From: Amanda Scholes on behalf of Planning.Responses
Sent: 05 March 2021 08:10
To: Planning Scanning
Subject: FW: Application Y/151/20/PL
Attachments: Swept Path_210304.pdf; Site Map of Water Sources and Parking Areas_compressed.pdf

From: Ian Stocks [REDACTED] **On Behalf Of** FRS Water and Access
Sent: 01 March 2021 13:59
To: Maria Tomalova <Maria.Tomalova@arun.gov.uk>
Subject: RE: Application Y/151/20/PL

Fire Engine Swept Path - Part 1

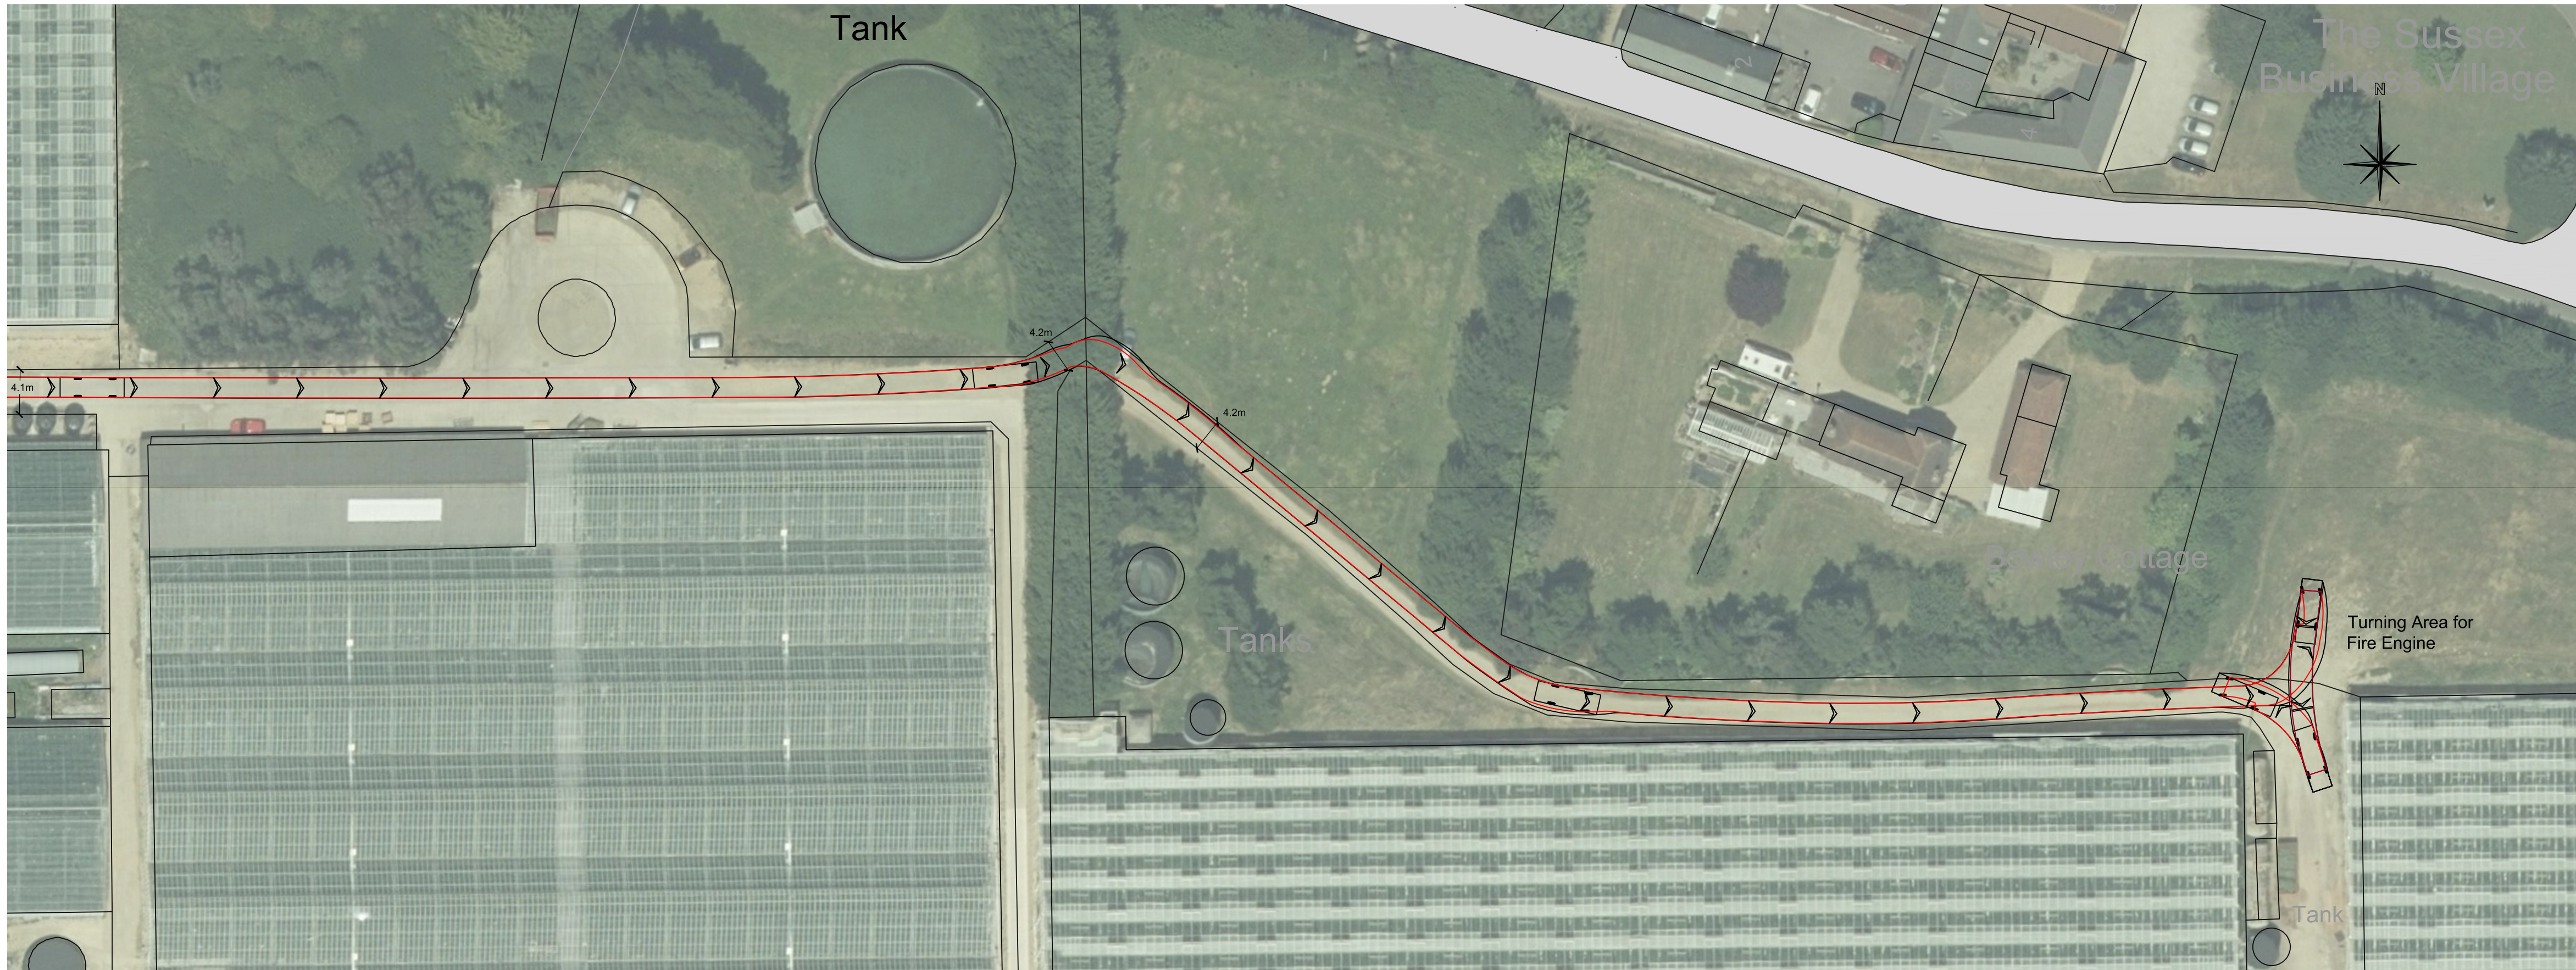
The size and location of the alternative water supply looks like it would meet with the requirements, we will need is evidence of suitable access and a hard standing area for a fire appliance to enable the water to be extracted and used to extinguish a fire. Also evidence will be needed to show the access from the reservoir to the accommodation area containing 8 mobile homes and that they are within the required distance. There is a fire hydrant out on lake lane within 90 metres of this area but there is no access route from the road to enable it to be used.

Thank you for your email.
I am afraid you should provided an evidence showing suitable access as required by Fire And Rescue Service.

In response to West Sussex Fire and Rescue comments please find attached a swept path analysis for the site. This confirms a suitable and safe access is available to the site.
